Our Ref: K/31/21/DOC

Approval of details reserved by condition imposed under K/10/21/HH relating to condition 3-details of balcony sides being obscured.

2 Meadowview Peak Lane Kingston BN16 1RN

Arun District Council have decided to **REFUSE details reserved by condition for the following reasons:**

Drawing No. 221/612/5

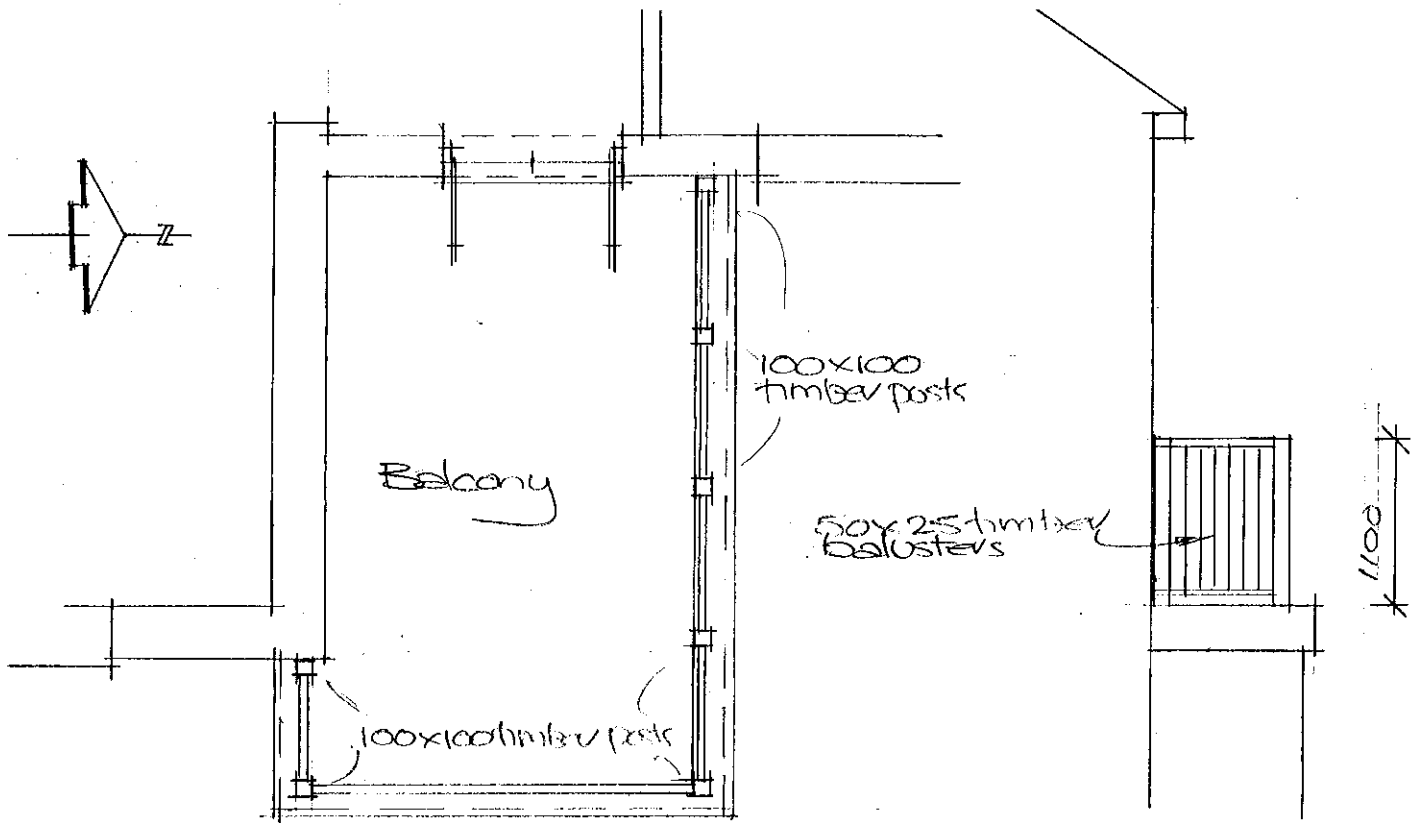
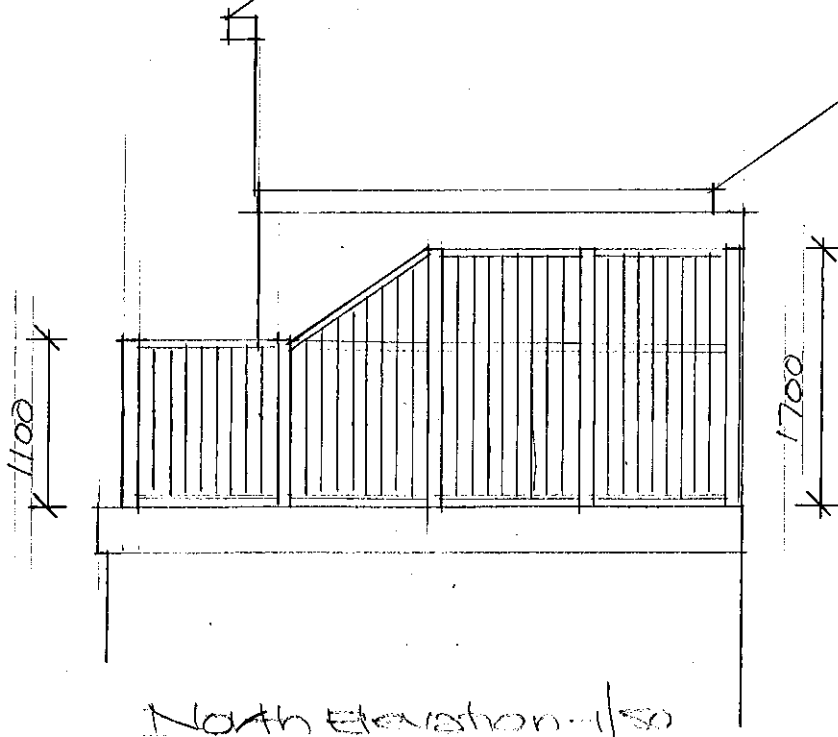
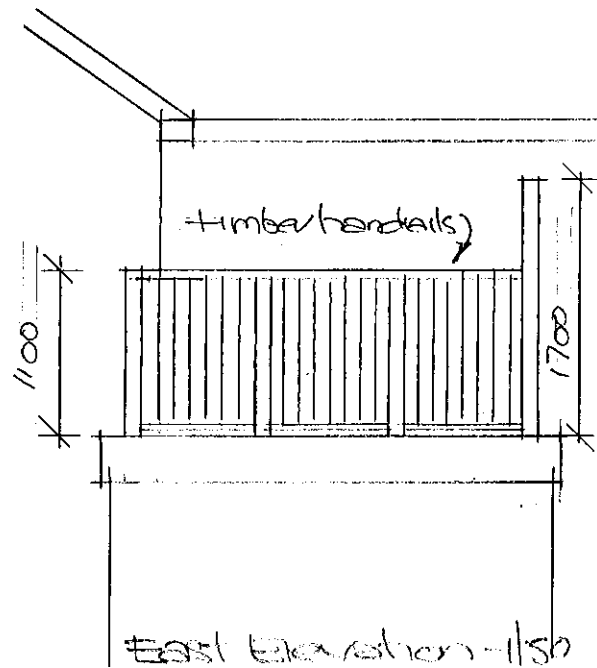
The north side of the balcony screen is not indicated on the submitted plans to be obscurely screened to a height of 1.7m for its whole length and the south side of the balcony is not indicated to be obscurely screened to a height of 1.7m. From the information submitted it has not been satisfactorily demonstrated the balustrading is solid or whether it has gaps allowing views through it and therefore it is not clear whether it would meet the requirements of obscure screening.

The sides of the balcony shall at all times be obscurely screened to a height of 1.7m in accordance with details to be submitted to and approved by the Local Planning Authority prior to installation.
